From: Andrew Mooney
Sent: Wednesday, 22 August 2018 9:47 AM
To: Bianca Thornton
Subject: RE: Revised Road Plans - Jacfin Horsley Park Stage 1 MOD 1 (MP 10_0130 MOD 1)

Engineering Assessment Comments with Proposal

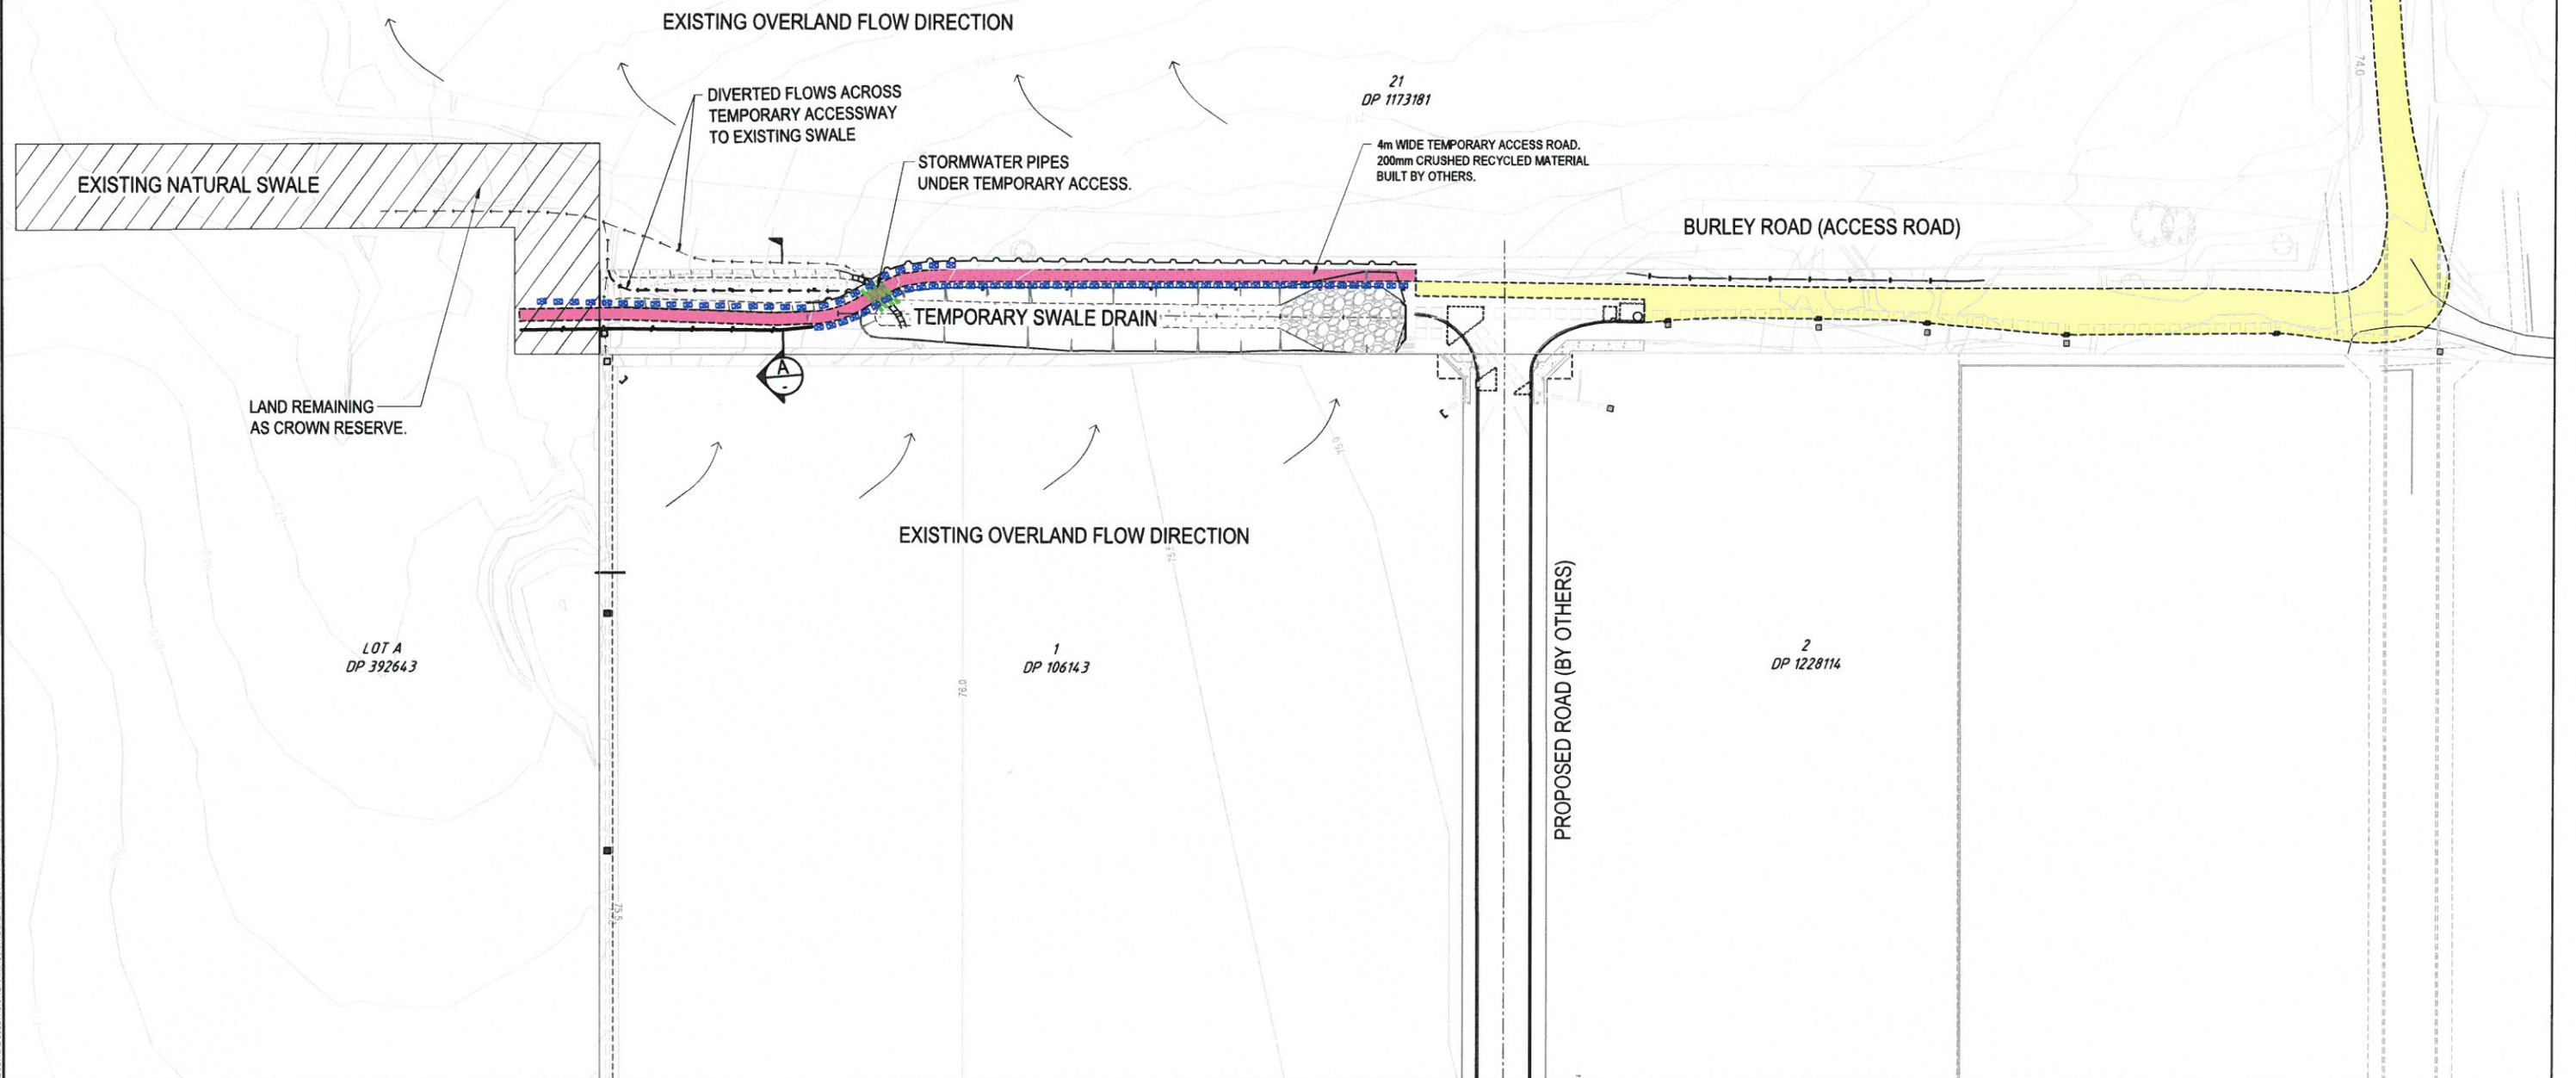
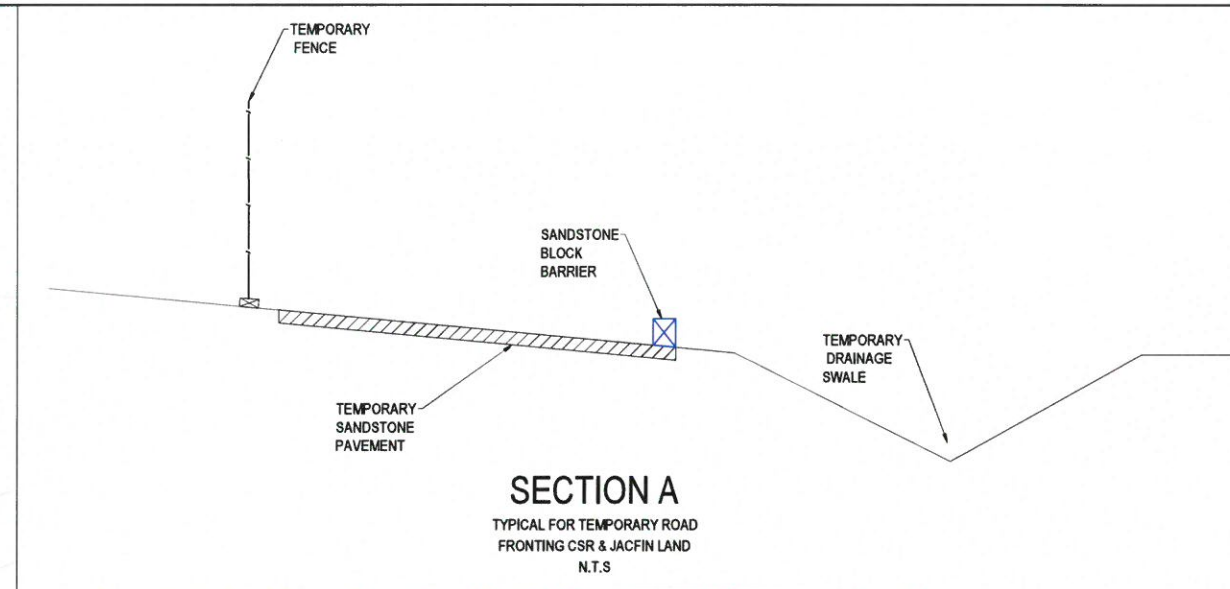
During consultation with the Jacfin Development Team the sequencing of the proposed works on Burley Road and the continued use of the access road were discussed. It was highlighted that the Jacfin Team will need to liaise with the adjoining property owner to ensure their access is not impeded by the ongoing construction works.

Council acknowledges the use of the unformed road and access for the Jacfin site. Council does not have an issue with the delivery of machinery for earth works via the access way. However the access up to the proposed internal road of the CSR site to the intersection of Burley Road and Old Wallgrove Road is currently under construction and movement of plant may be limited. Jacfin should liaise with the CSR Development team to coordinate movement of machinery. If access from the unformed Burley Road location becomes an issue, due to circumstances beyond the control of CSR and the Fairfield City Council, an alternative access point to the Jacfin site can be achieved via the corner of Greenway Place and Horsley Road, Horsley Park. Aerial views indicate an access way has been formed at this location point already.
